From: Sue Howell
Sent: 20 May 2019 16:17
To: Planning.Responses
Cc: Anita Gardner
Subject: RE: Planning Consultation on: WA/7/19/RES

Comment from Greenspace

APPLICATION NO: WA/7/19/RES

Description of Works: Approval of reserved matters following outline consent
WA/26/18/OUT for layout & scale for 6 No. dwellings & 6 No.
detached garages.

PJ DEVELOPMENTS LTD 2 Square Chambers 23 High Street Emsworth PO10 7AQ Tel: 0843 289 3430 Email: enquiries@pjdevelopmentsltd.com	
PROJECT: FORMER LANES END	
SITE PLAN OUTLINE PLANNING APPLICATION	
DATE: JANUARY 2019	DWG. NO 19-001 PL02
SCALE @ A1: 1:200	
REV: C

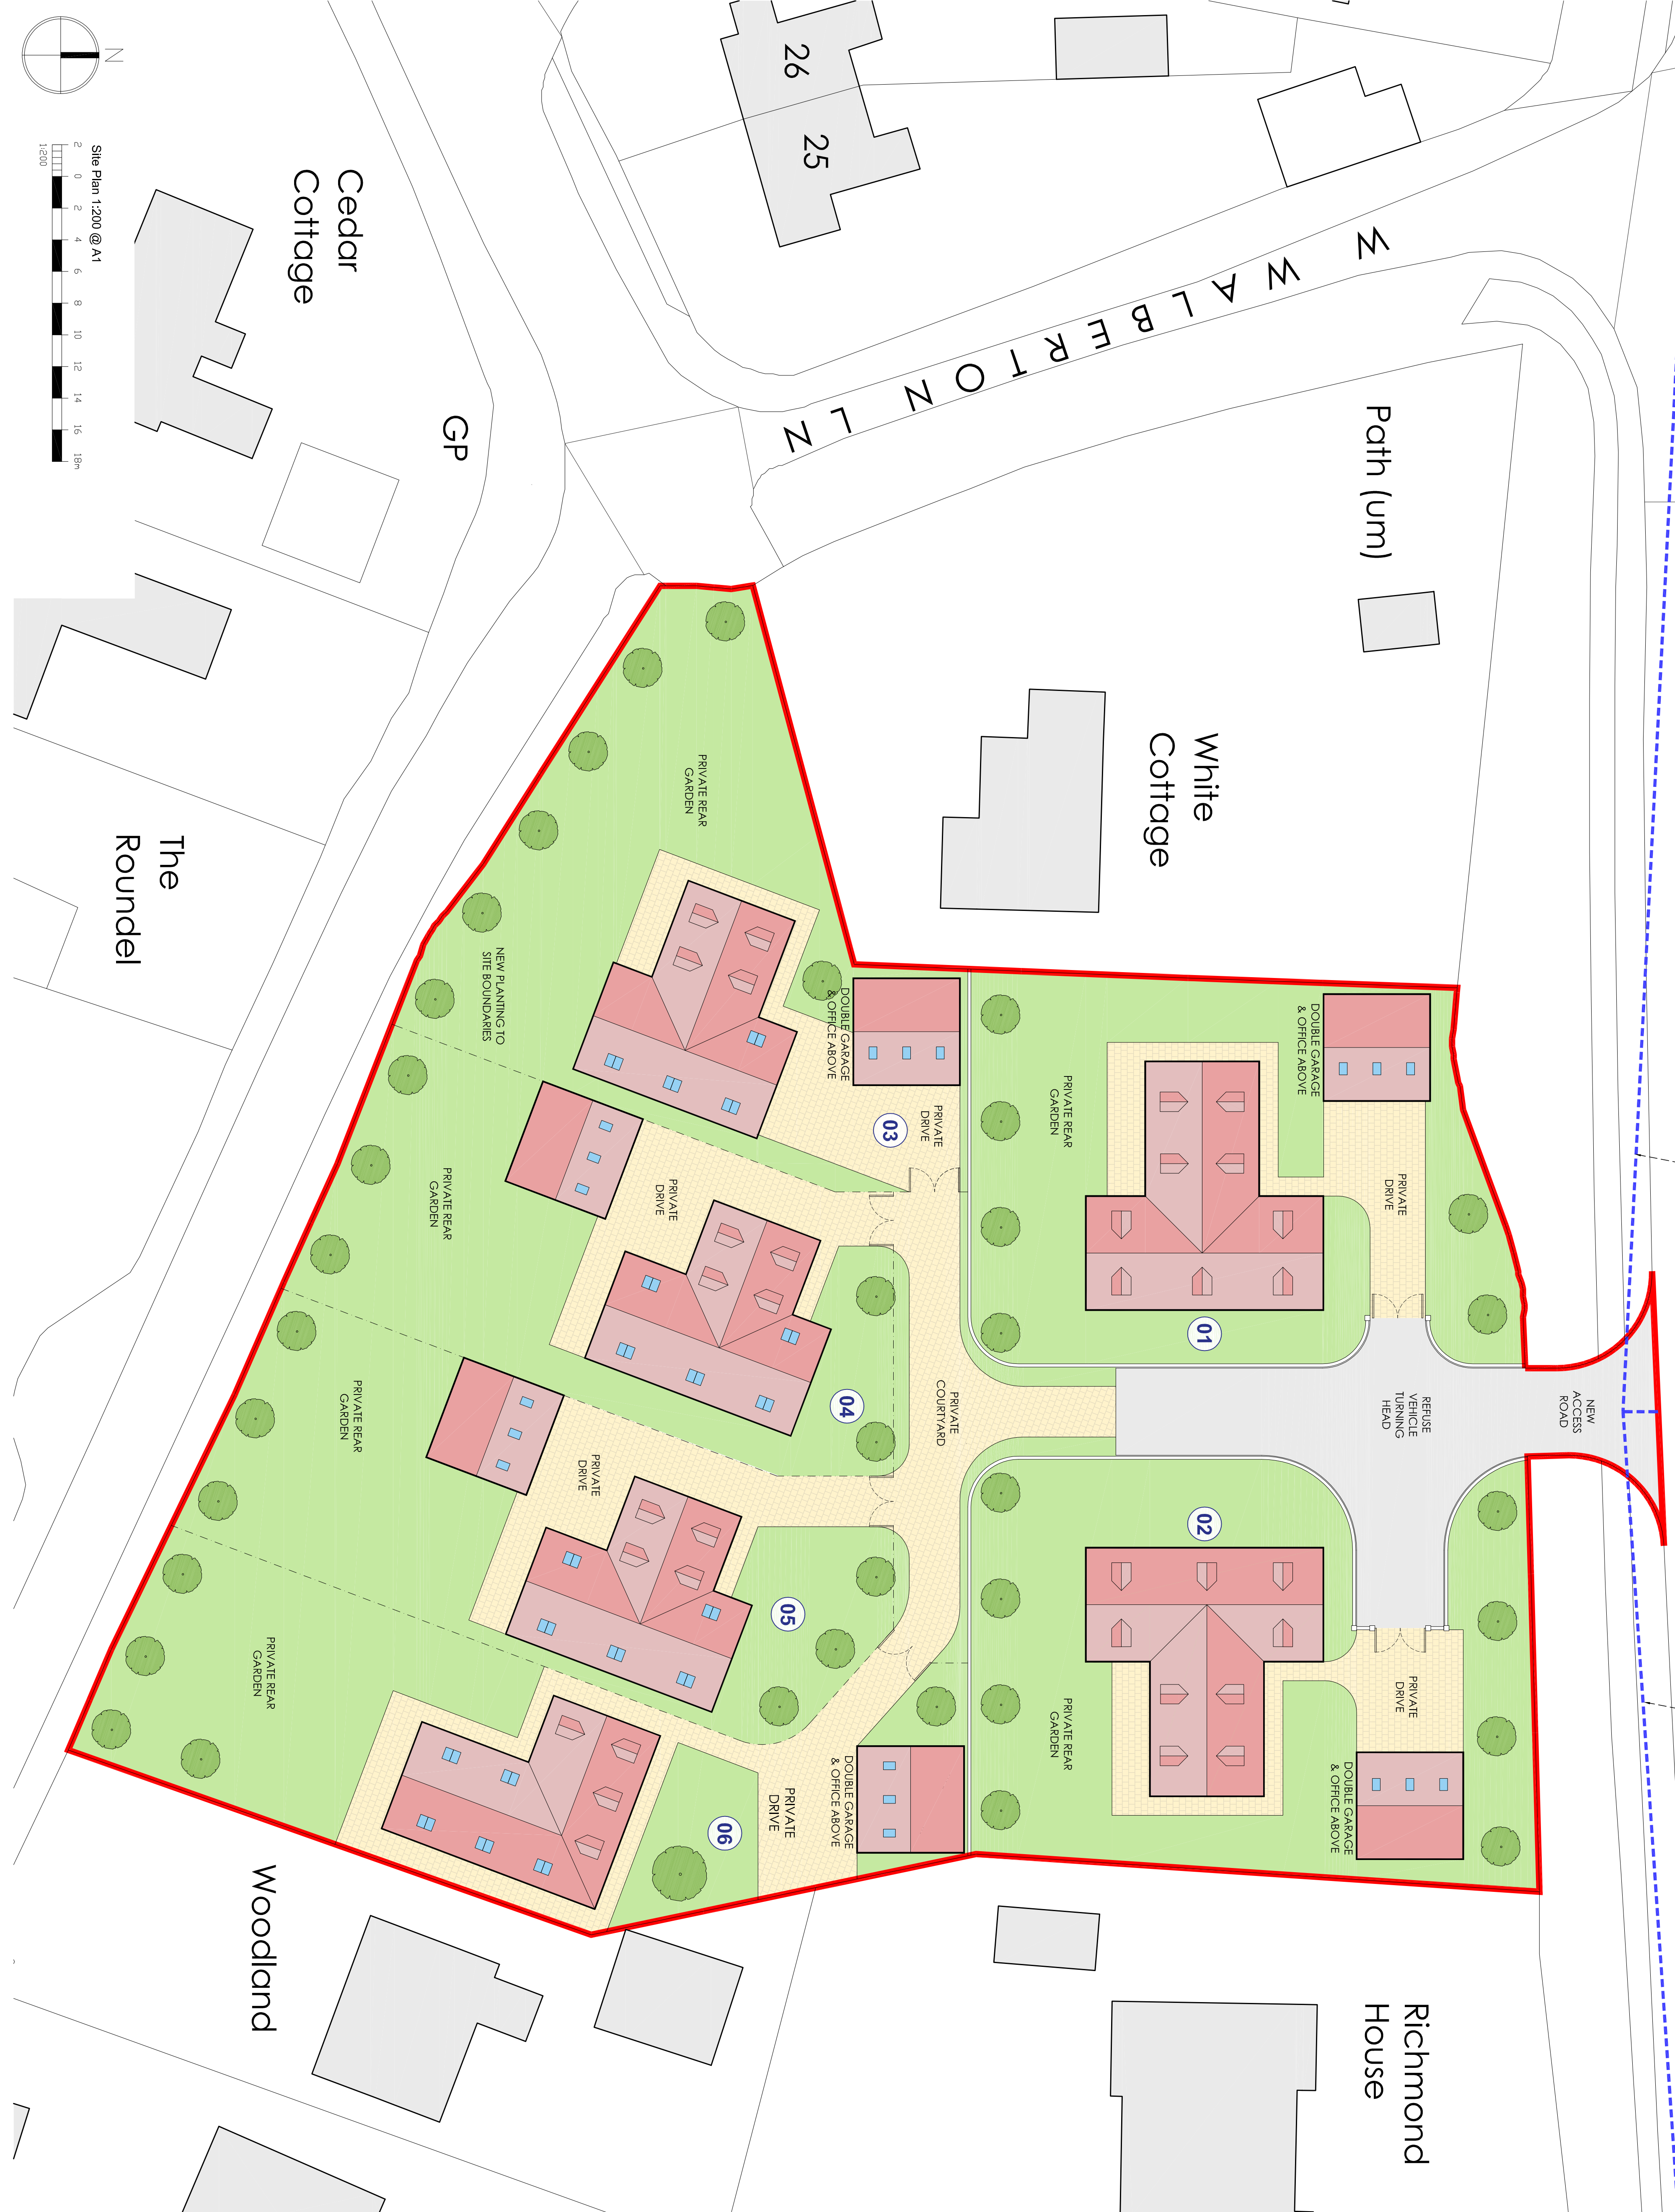
I have viewed the documentation and plans submitted and can advise that there is insufficient detail provided re landscaping.

A detailed landscape scheme will need to be submitted in plan form which will need to propose a varied and appropriate planting mix with a good palate of both evergreen and deciduous trees and shrubs, both ornamental and native. Any trees proposed will need to be sufficient in height to provide instant impact whilst still being an appropriate size to aid establishment. The planting proposed may be required as mitigation for vegetation to be removed as part of this schemes development.

The landscape scheme will need to be detailed in plan form and also shown in context of the existing vegetation to be retained. Any proposed tree removal will need to be in consultation with Arun District Councils Tree Officer and approved before commencement. Tree protection measures will need to be in place for any retained trees and hedges and to be applicable to those bordering the site from adjacent land.
